# CITY OF MERCER ISLAND

## REVISION/DEFERRED SUBMITTAL FORM

GELOTTE HOMMAS DRIVDAHL  
ARCHITECTURE

Re: Itemized Revisions for Permit 1706-084

S2.0

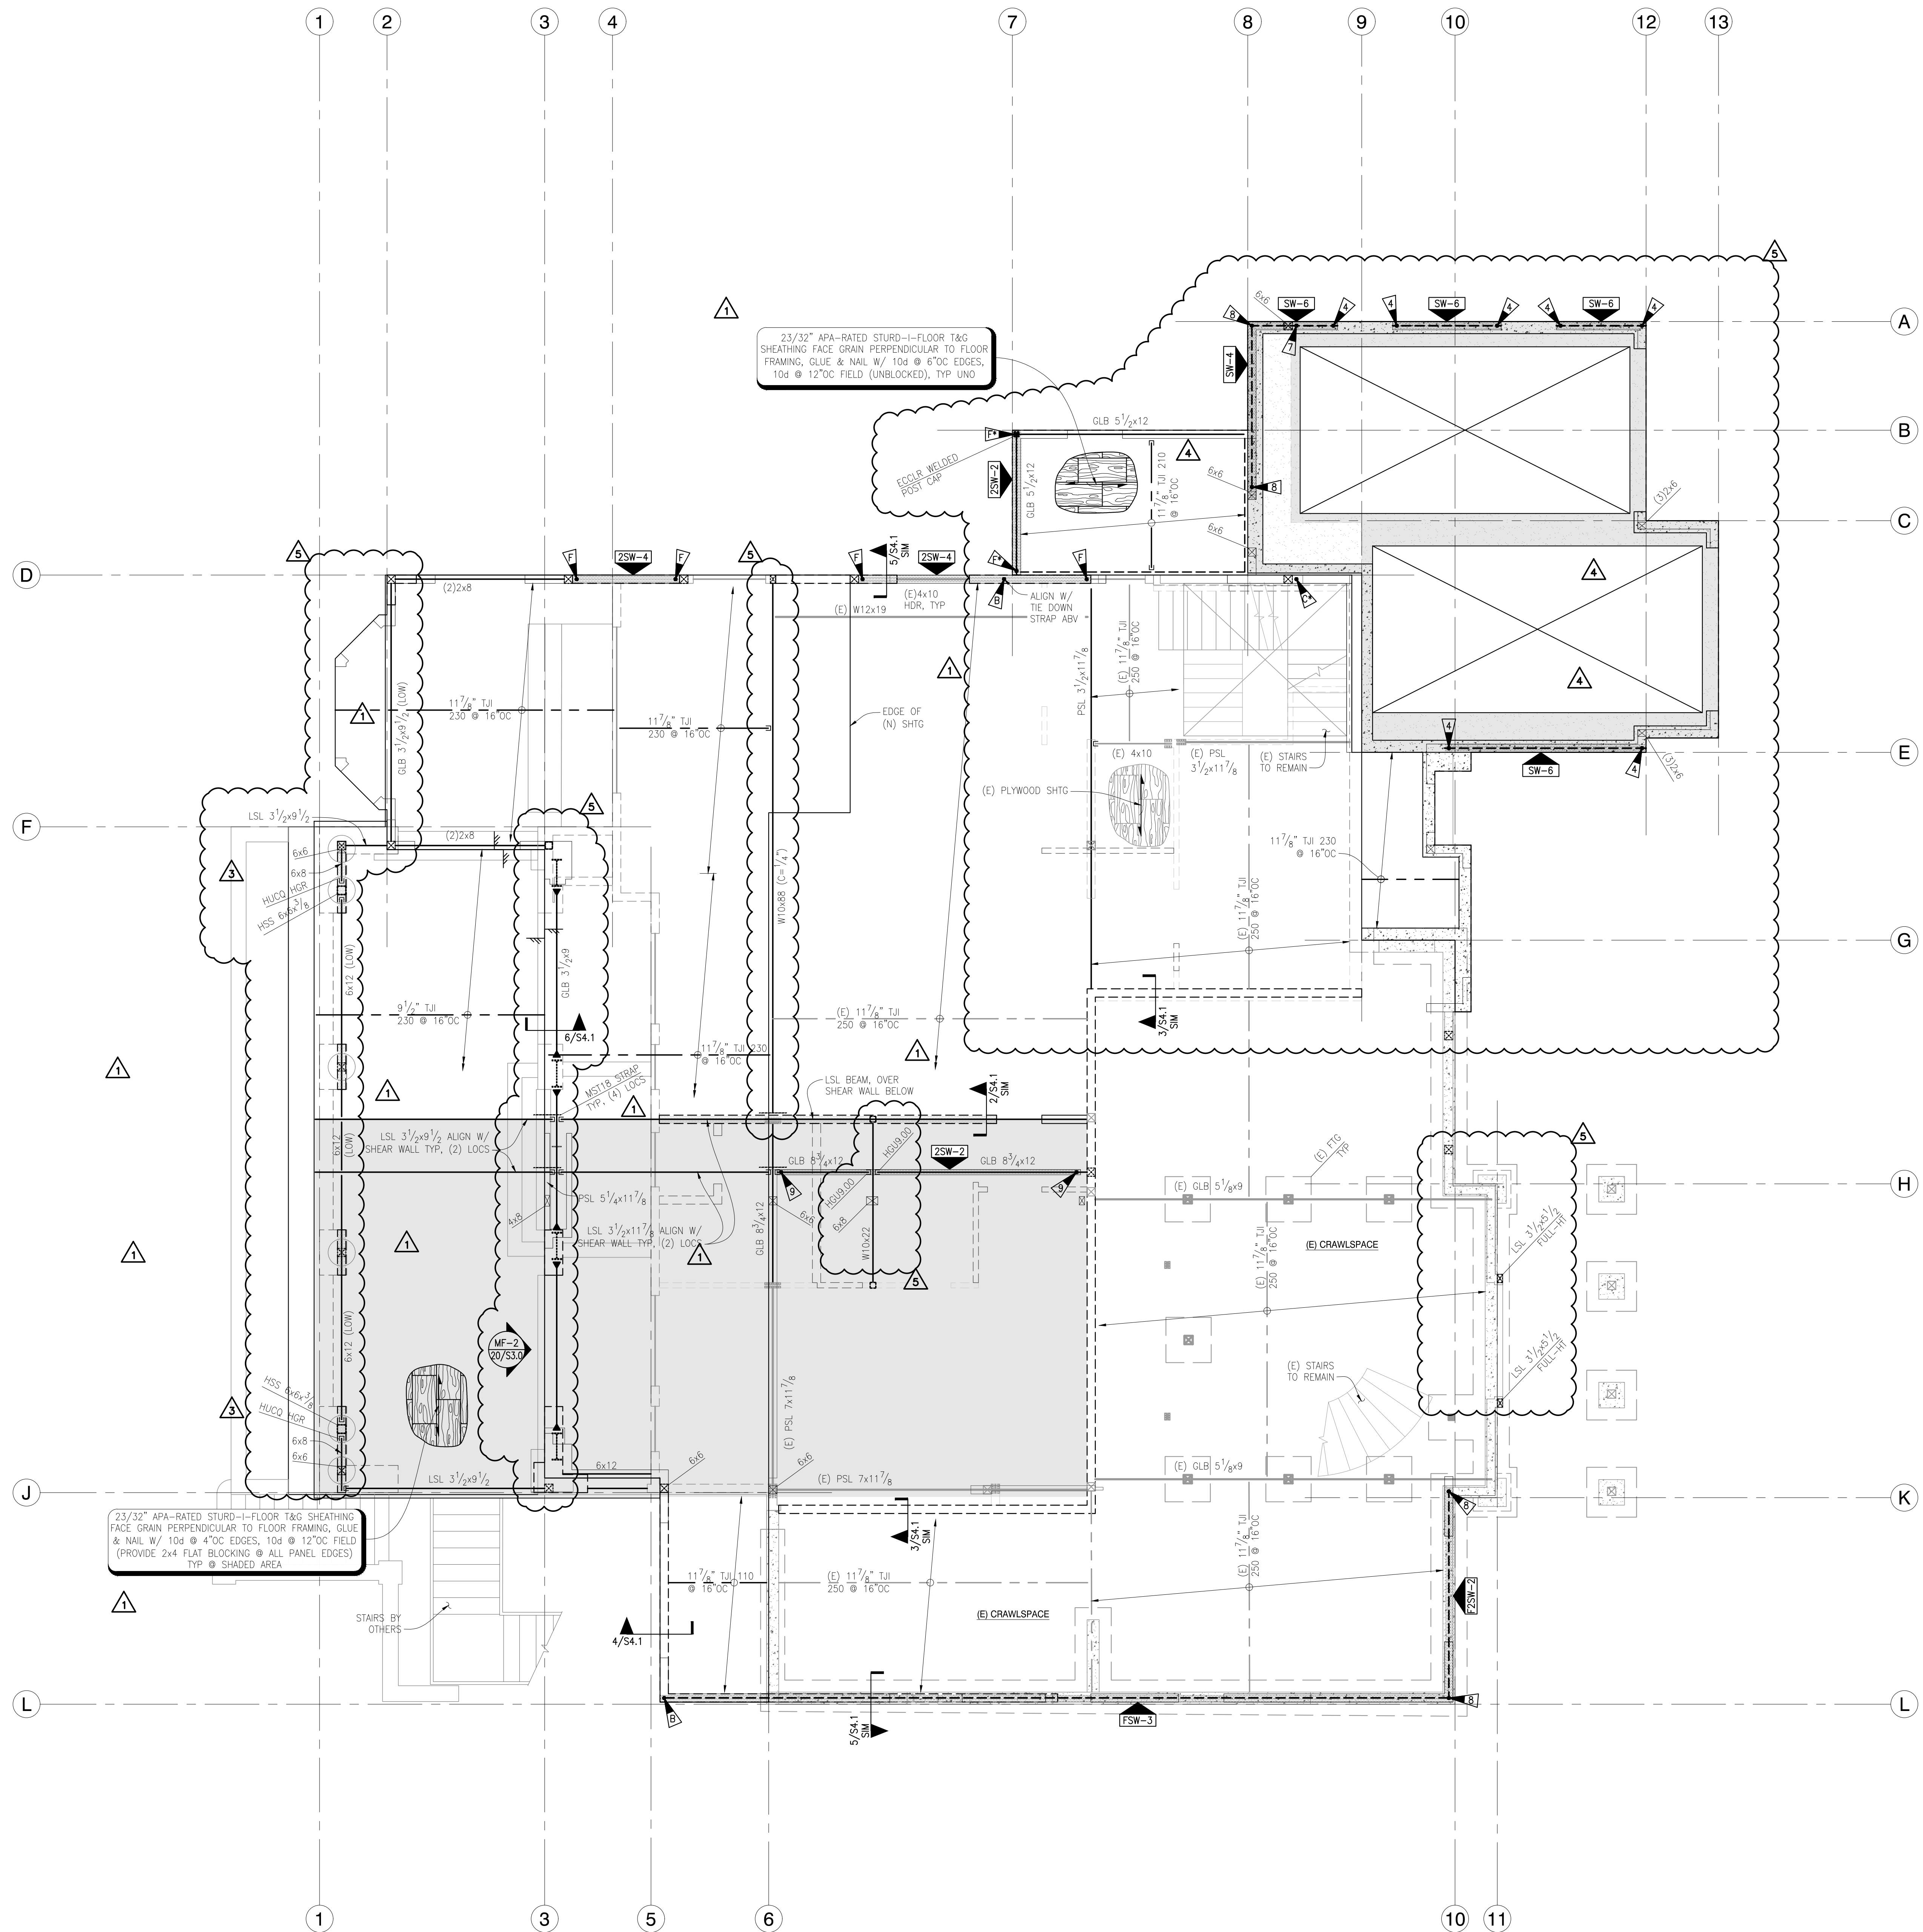
Sheet S2.0: Revised garage to reflect auto lift pits.

Sheet S2.0: Add/revise BBQ patio (between grid lines 2 and 4).

Sheet S2.0: Revised foundation at west facing patio.

Sheet S2.0: Revised footing (adjacent grid H6)

STRUCTURAL UPPER FLOOR FRAMING PLAN
S2.2

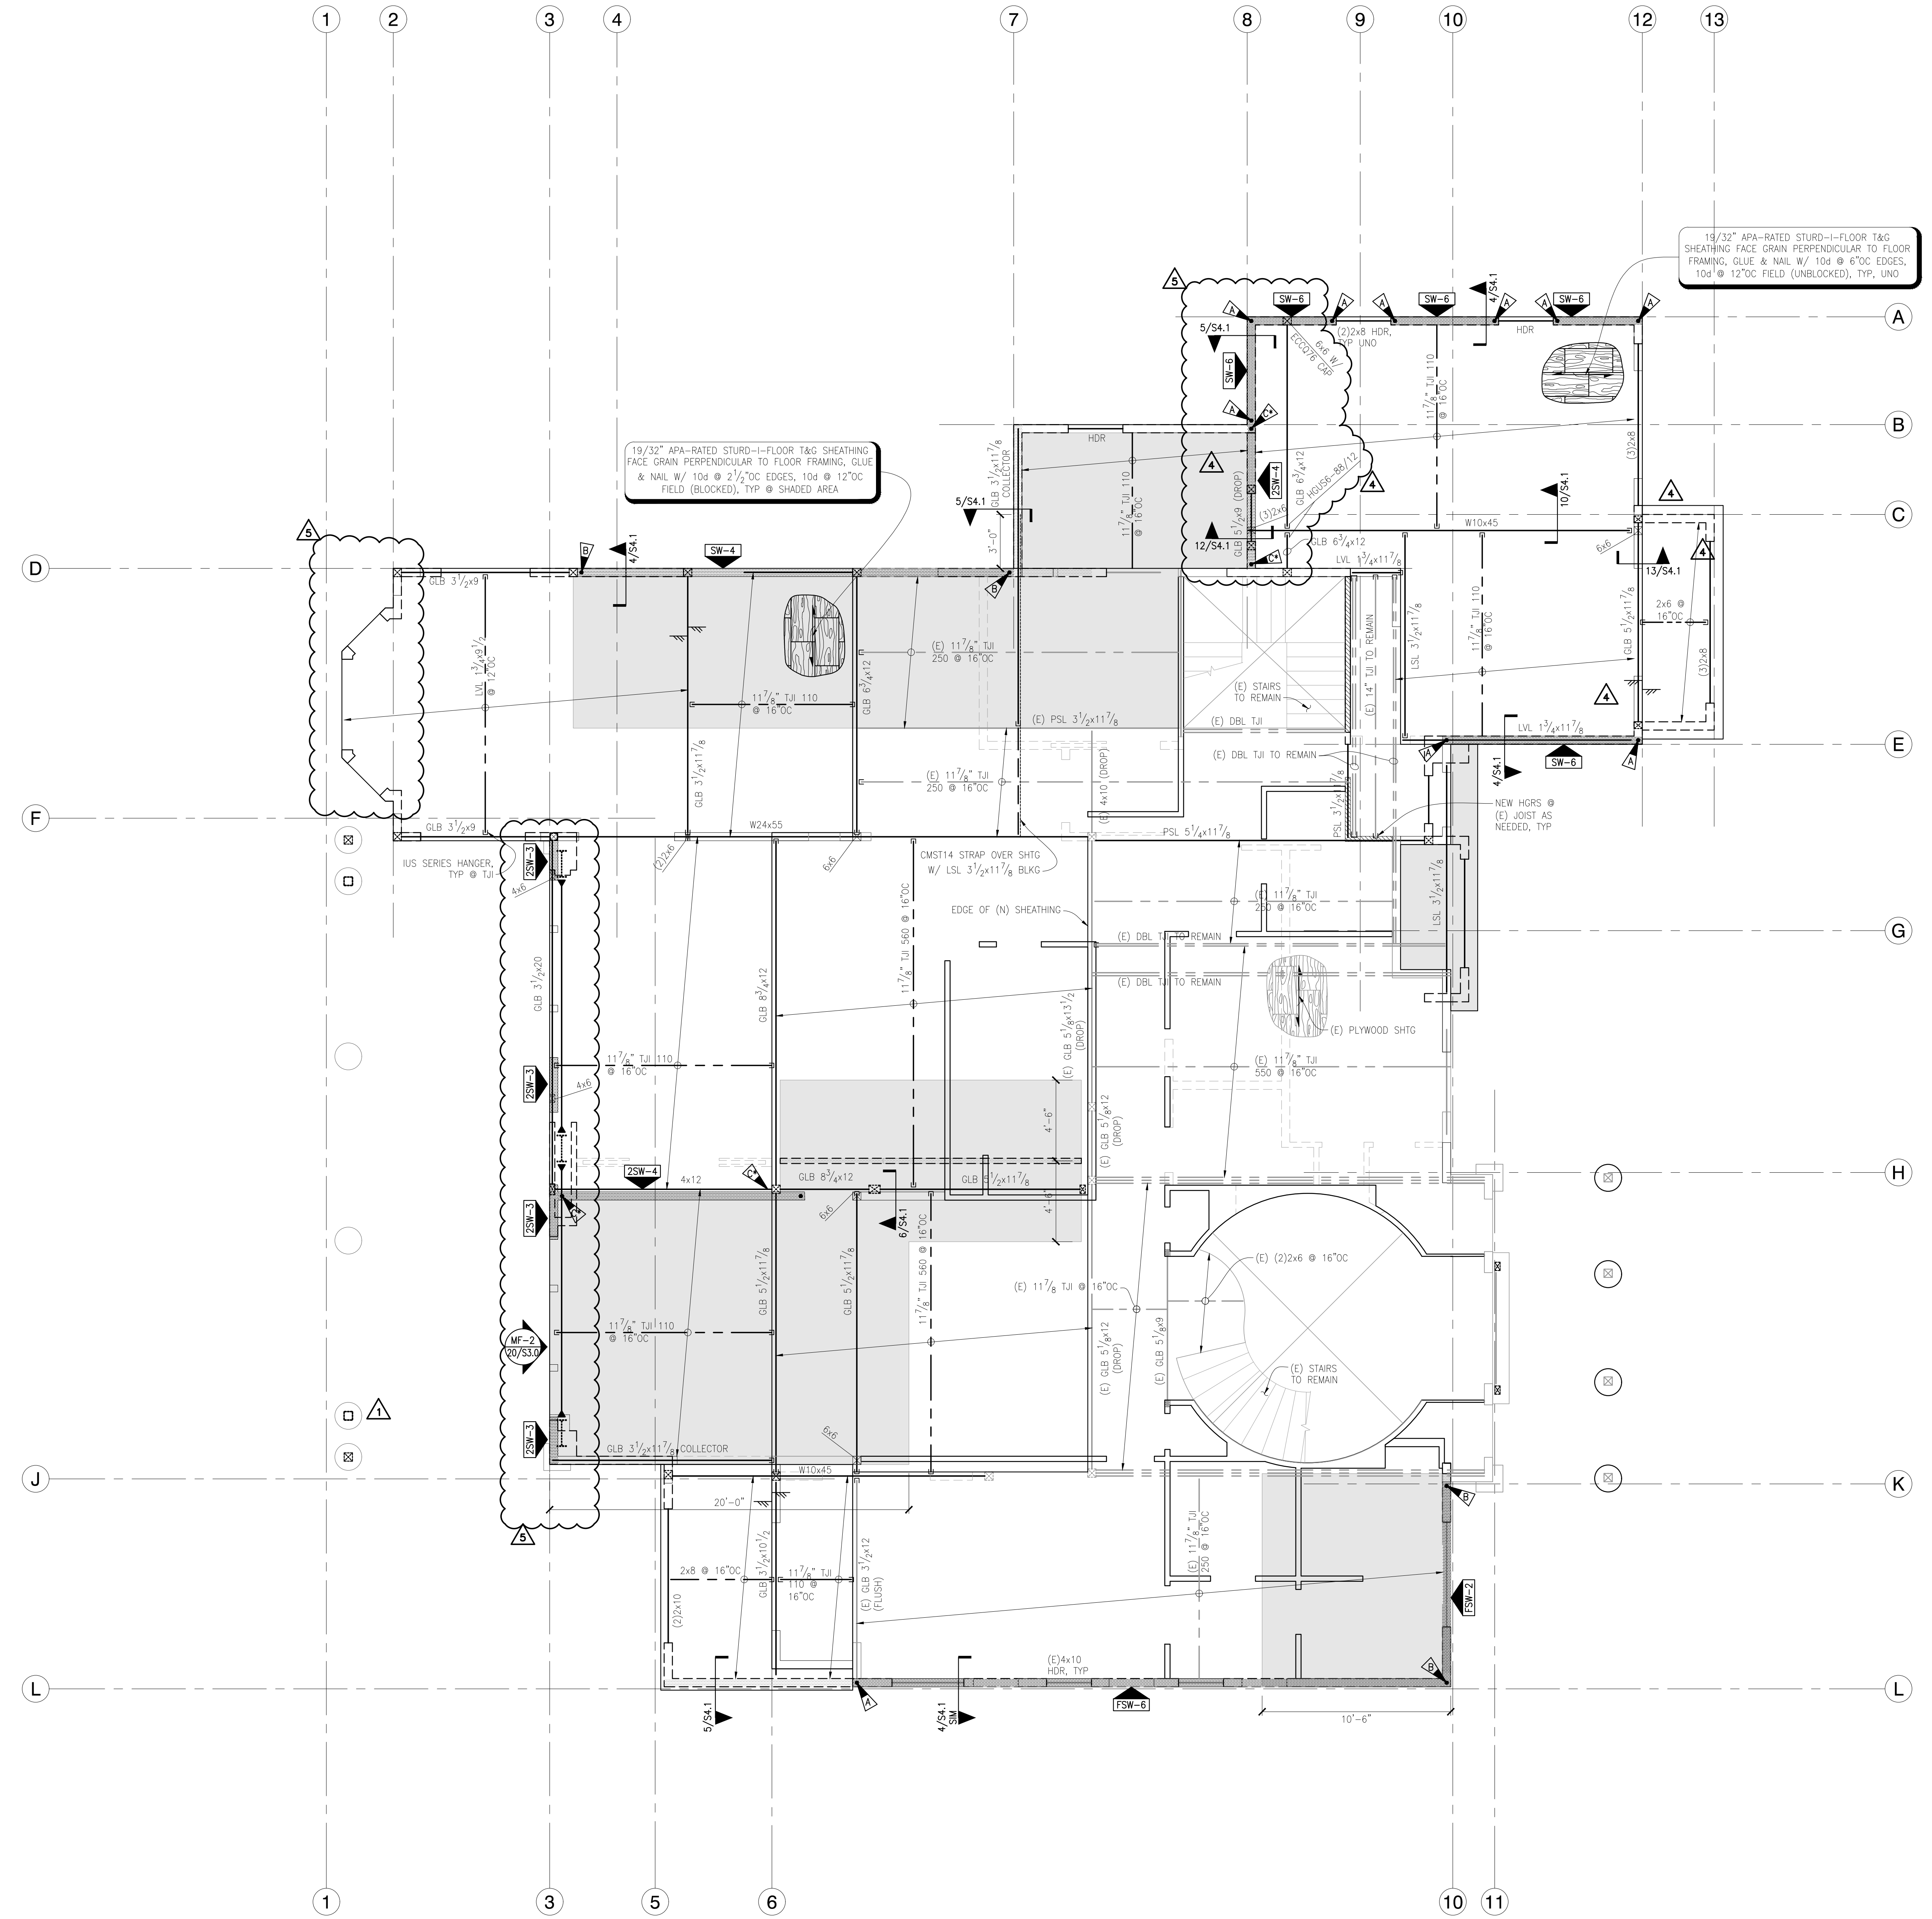
Sheet S2.2: Various revisions to framing (West facing bay unit, rear of garage, etc.)

S2.3

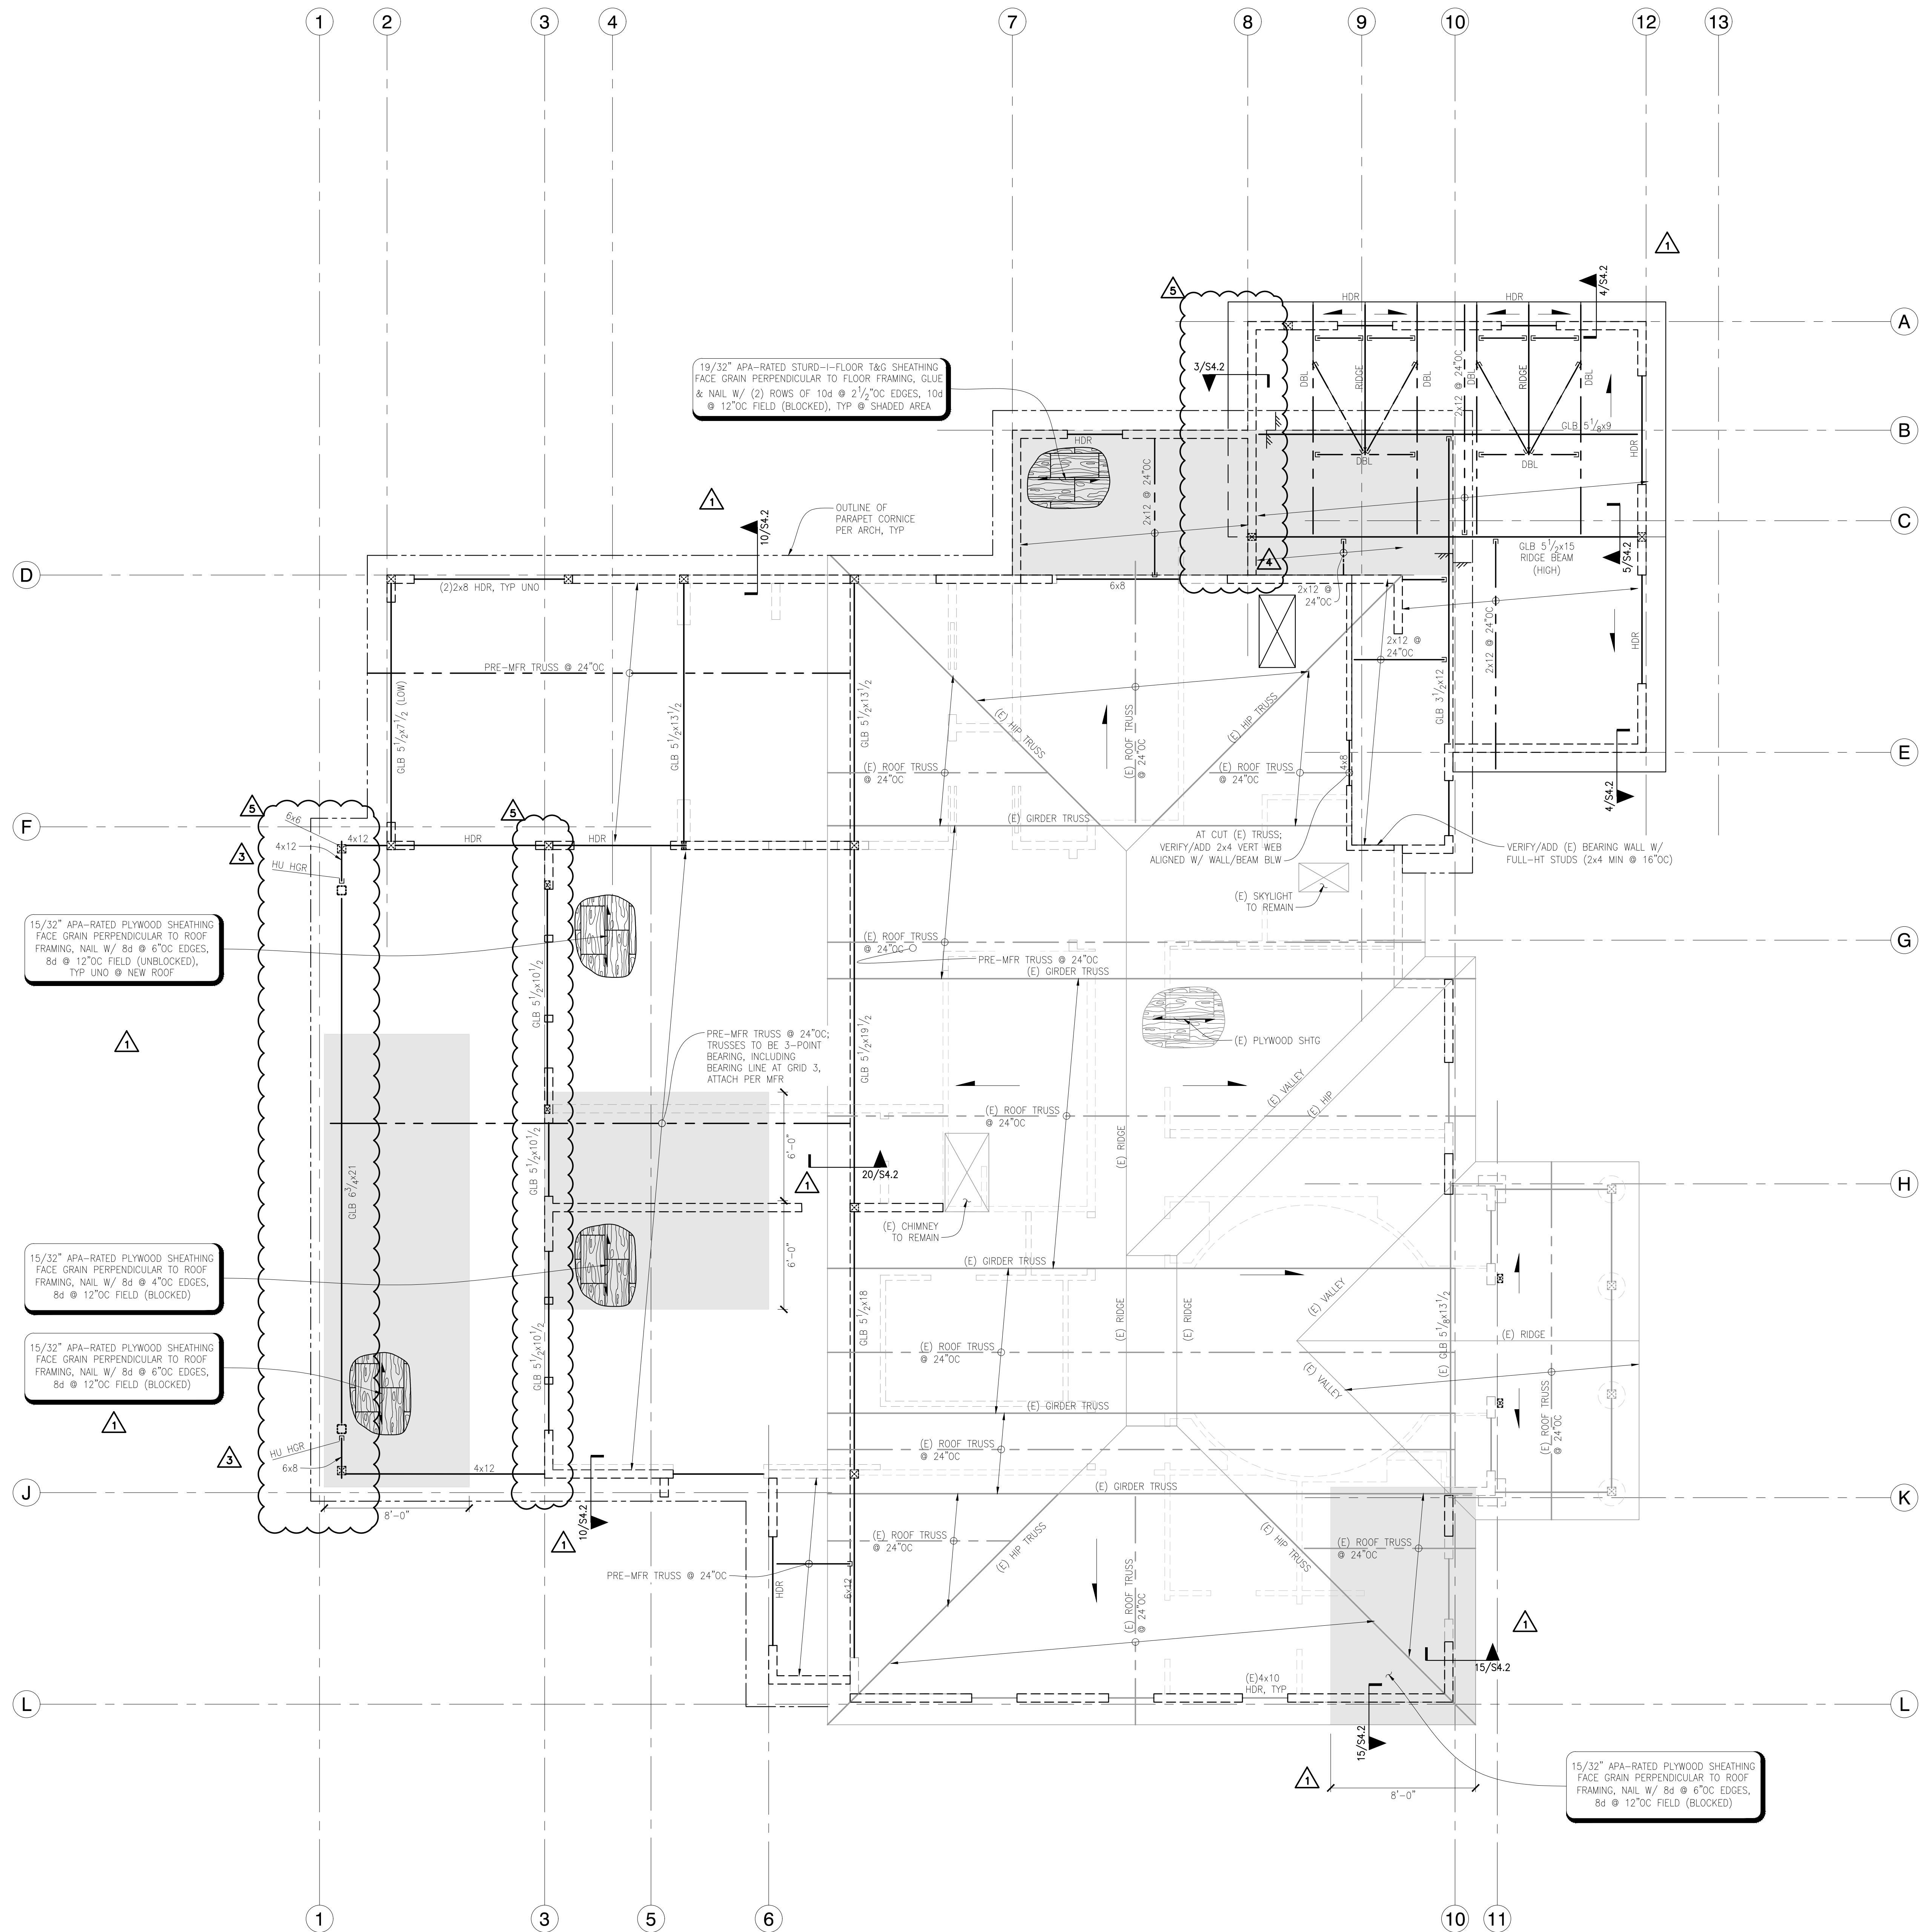
Sheet S2.3: Various revisions to framing (West facing patio, rear of garage, etc.)
